Rocglen Coal Mine Extension Project
(EPBC 2010/5502)
Whitehaven Coal Limited
Document Review Comments Sheet

Reviewer: Department of Sustainability, Environment, Water, Population and Communities

Document Title: Rocglen Coal Mine Extension Project Environmental Assessment

Date of Review: 15 April 2011

Figure 1: Vegetation of project site showing location and area of EPBC Act listed ecological communities to be impacted

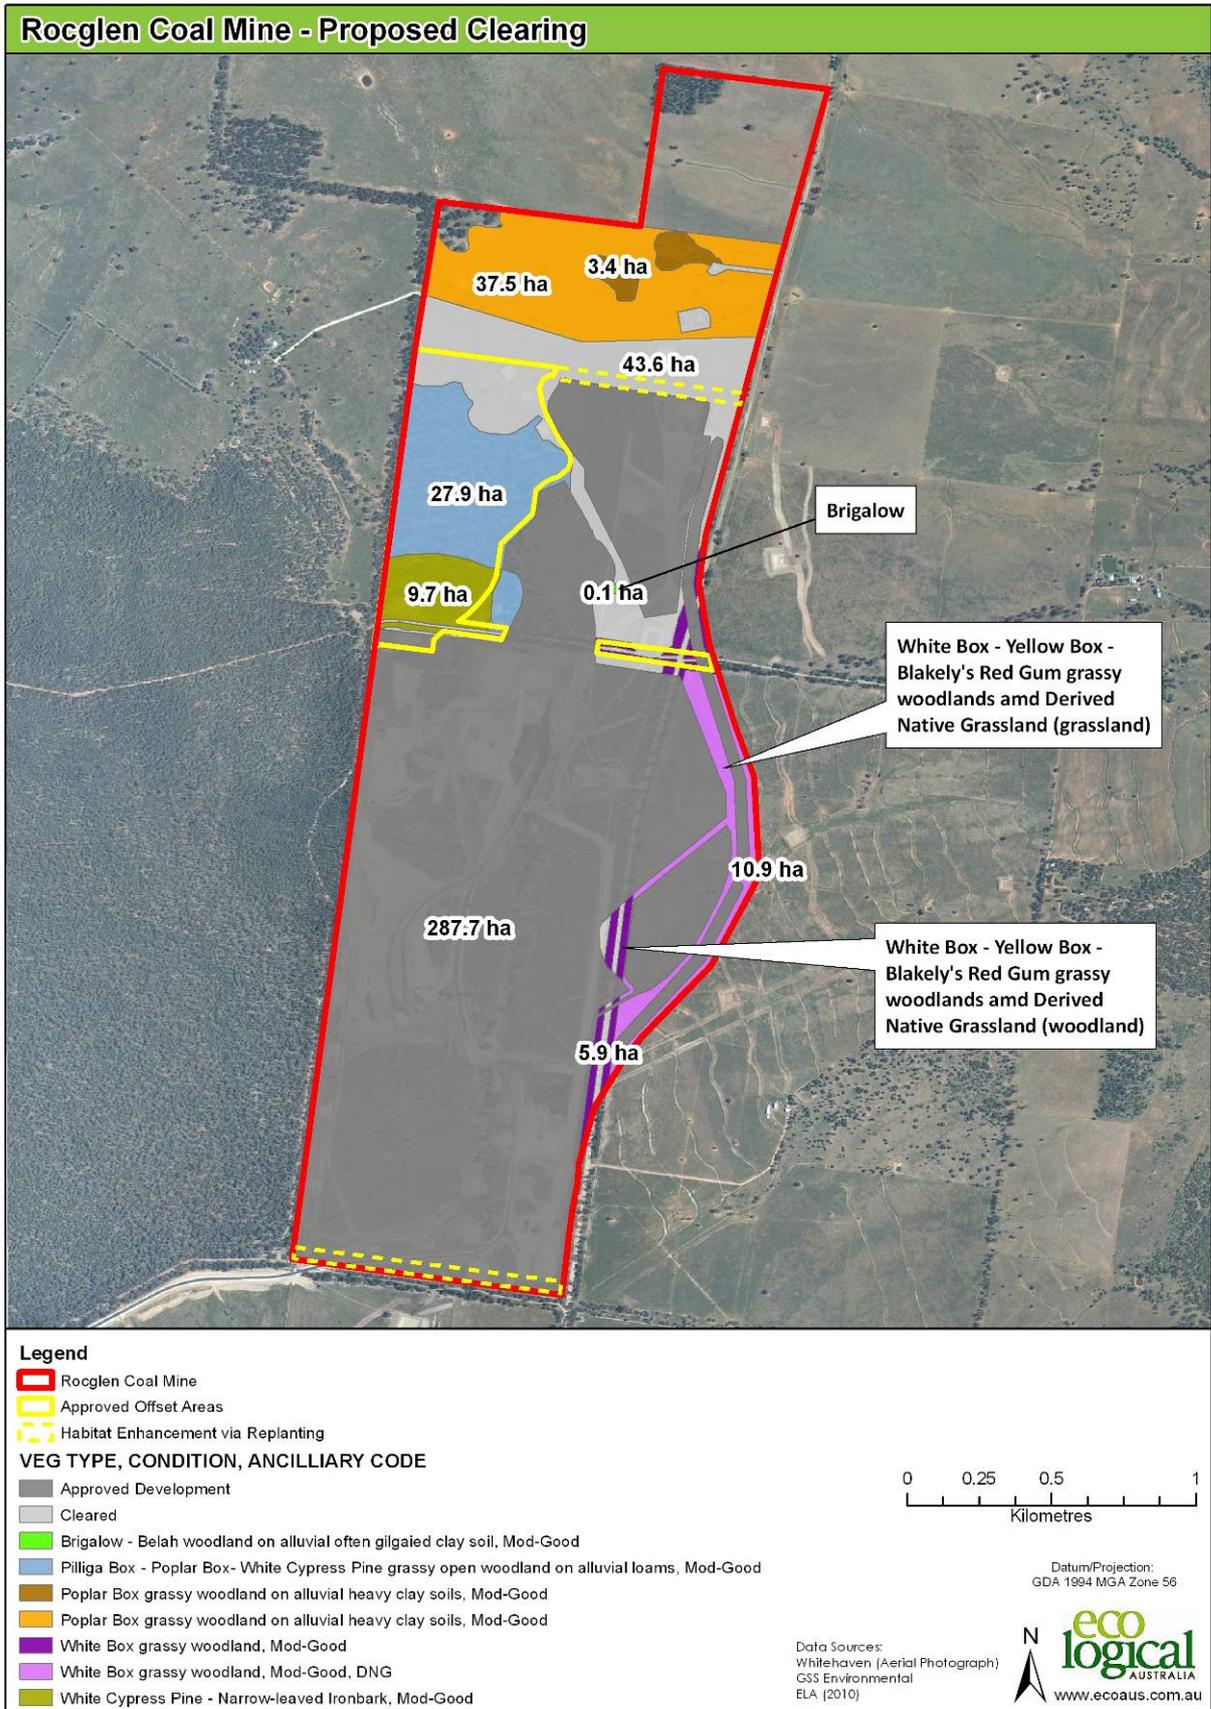
Section No.	Reviewer Comment	Company Response
General	<ul style="list-style-type: none">Please provide a map showing the EPBC listed ecological communities and suitable habitat for EPBC listed species within the project area.	
Offsets	<ul style="list-style-type: none">For clarification, please include a summary table of the hectare quantities, location and condition of the proposed offsets for EPBC-listed communities and EPBC-listed species habitat. Please also include further details of the extent of rehabilitation/restoration proposed for the White Box - Yellow Box - Blakeley's Red Gum and Derived Native Grassland Ecological Community as part of the offset strategy.To assist in the assessing the degree of risk of future disturbance to the proposed offsets, please provide details of all identified coal resources (including current or likely exploration or mining applications or leases) in the vicinity of the proposed offset sites.Please clarify whether, in considering the significance of Project impacts on habitat for EPBC species and ecological communities, consideration has been given to similar habitat impacts resulting from other planned or potential mining developments in the region, where this information is publicly available (including, but not necessarily limited to, proposed open cut coal miens in the Boggabri and Narrabri regions)). If not, please include details of how any relevant recent or predicted habitat clearance resulting from these developments may alter the importance of habitat on the project site, in the regional context.
